Your Ref
A/115/15/DOC
Our Ref
PLAN-011647
Date
06/11/2015

Proposal: Application for approval of matters reserved by condition imposed under A/167/14/PL relating to conditions 4, 13, 14, 18, 20 & 23 for protection of retained trees, programme of archaeological work, ecological mitigation report, foul water sewerage disposal, surface water drainage & storage of refuse & recycling bins.

Site: Former Pound Nursery, Roundstone Lane, Angmering, BN16 4AL.
A/115/15/DOC

TITLE
Site Layout
Section 104 Agreement Plan

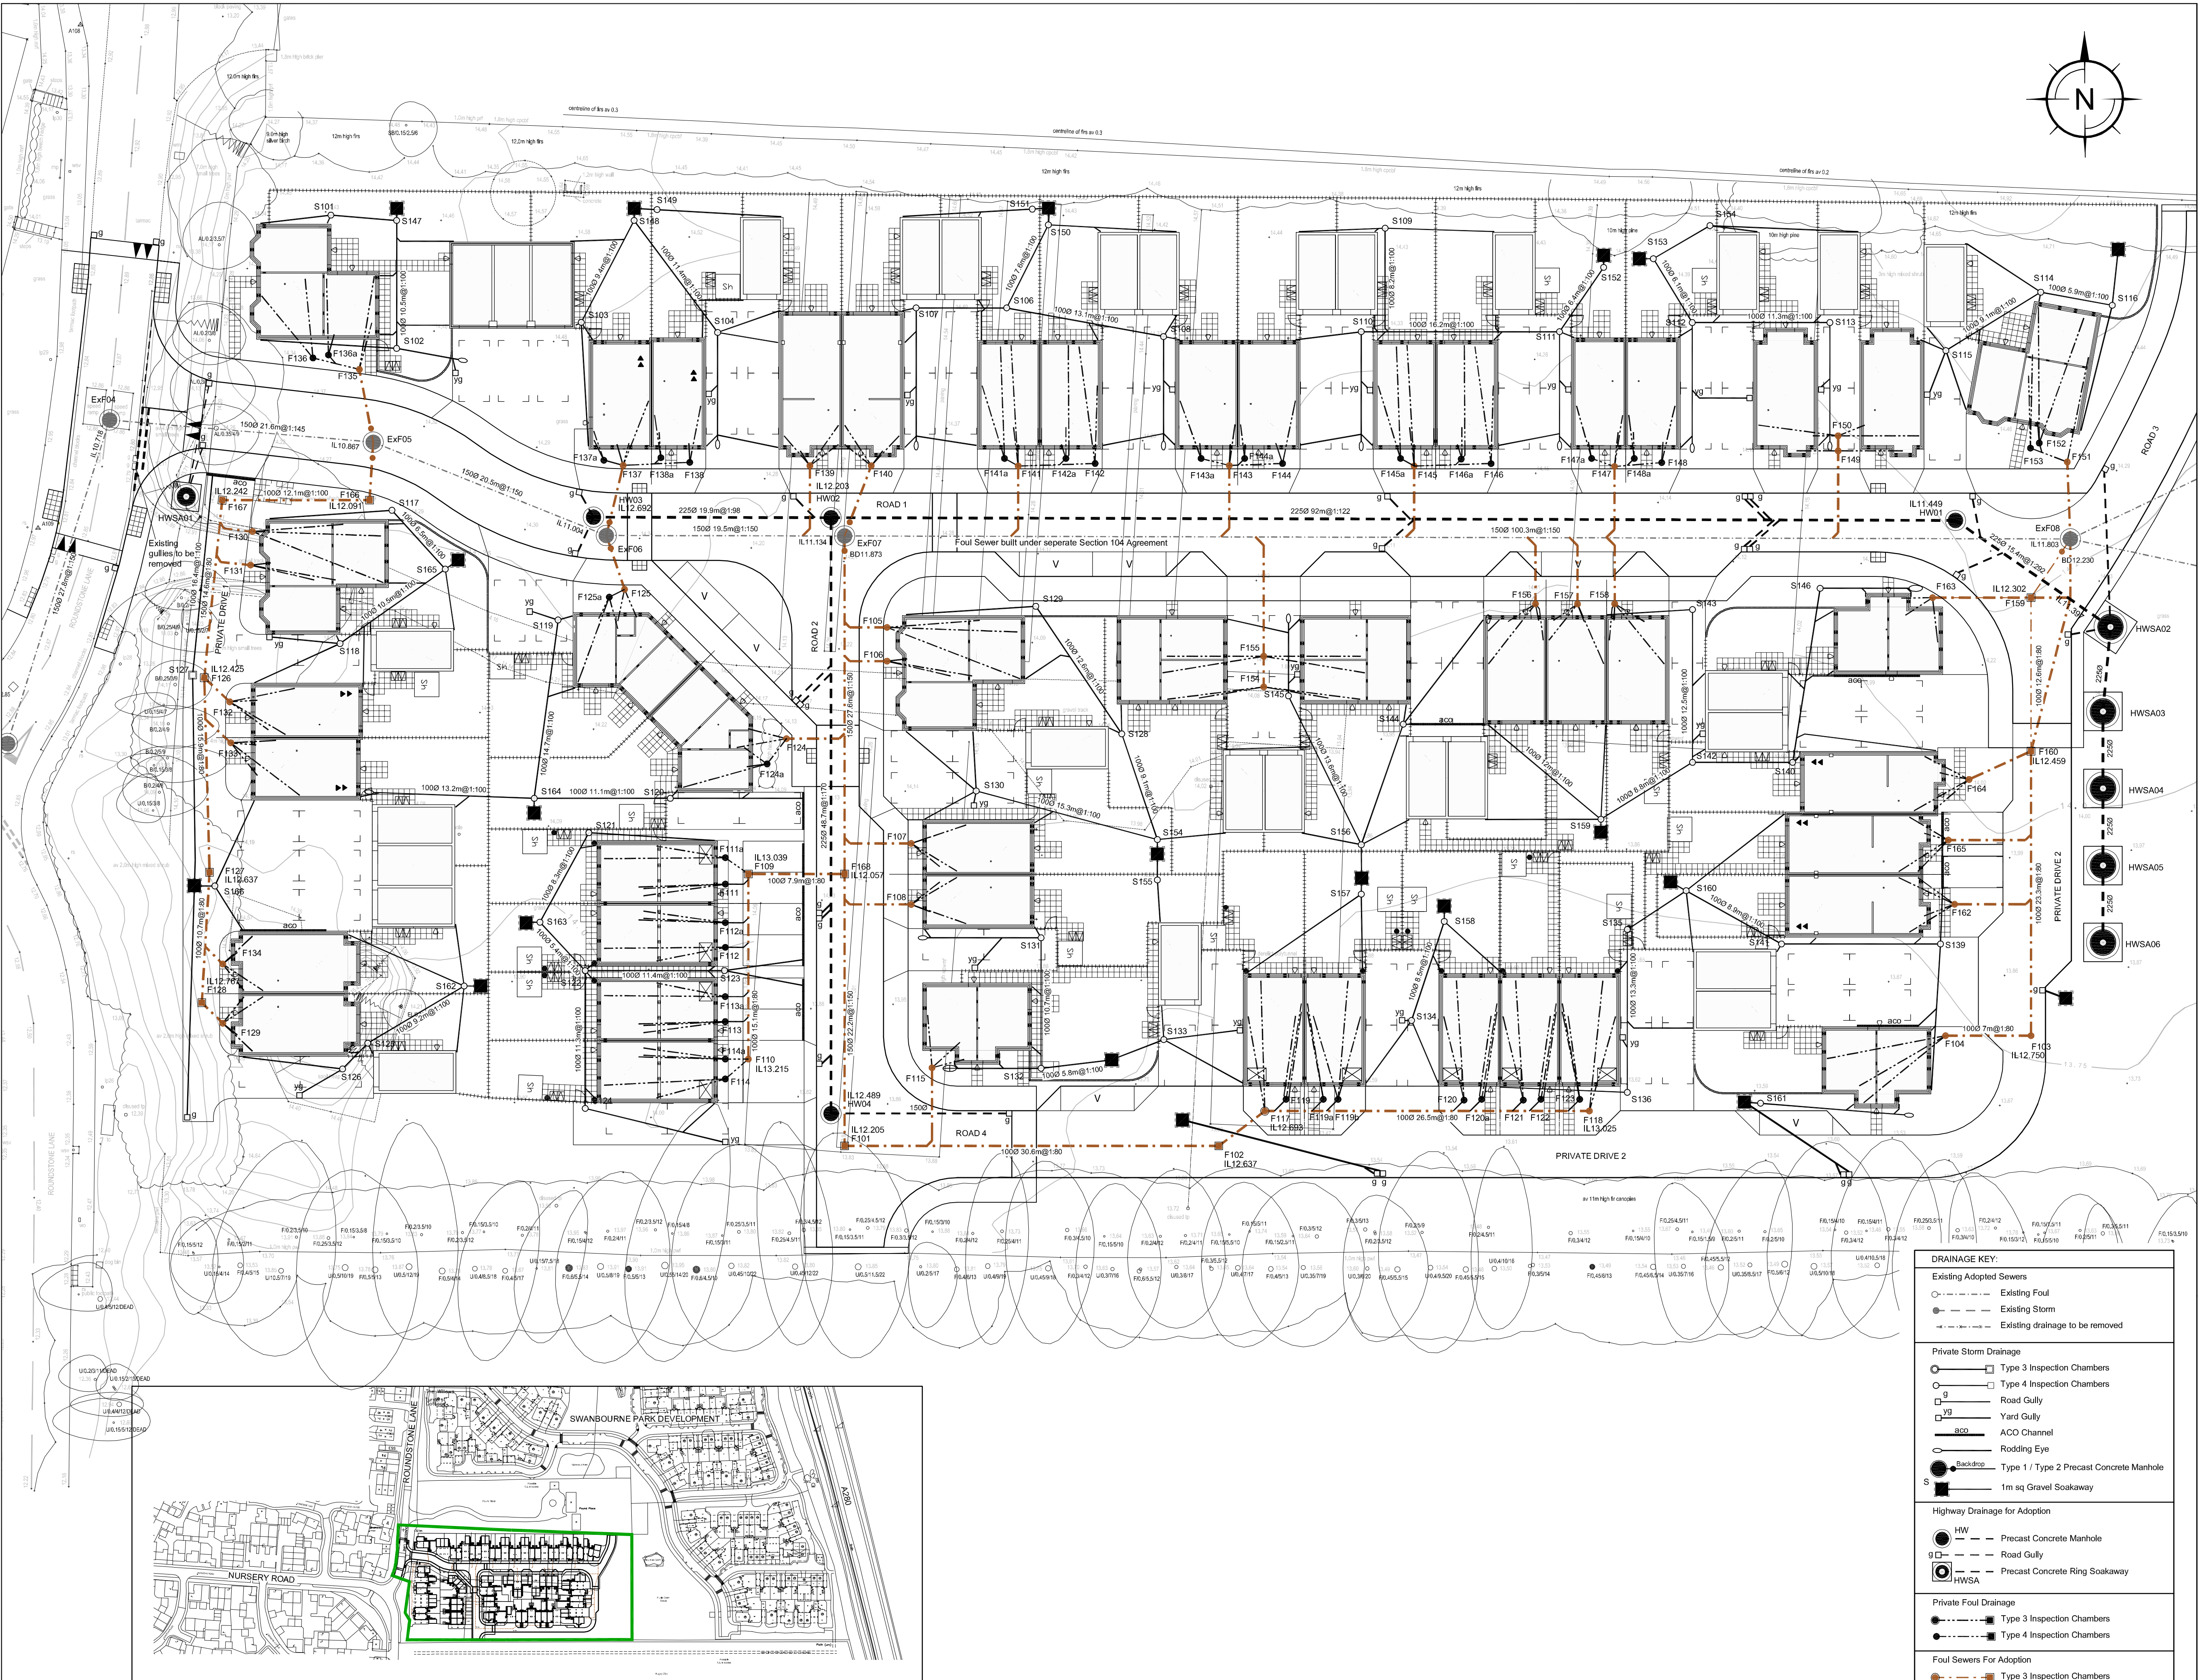
We regret that Southern Water cannot recommend discharge of foul condition as the drawing submitted does not comply with Sewer for Adoption standards.
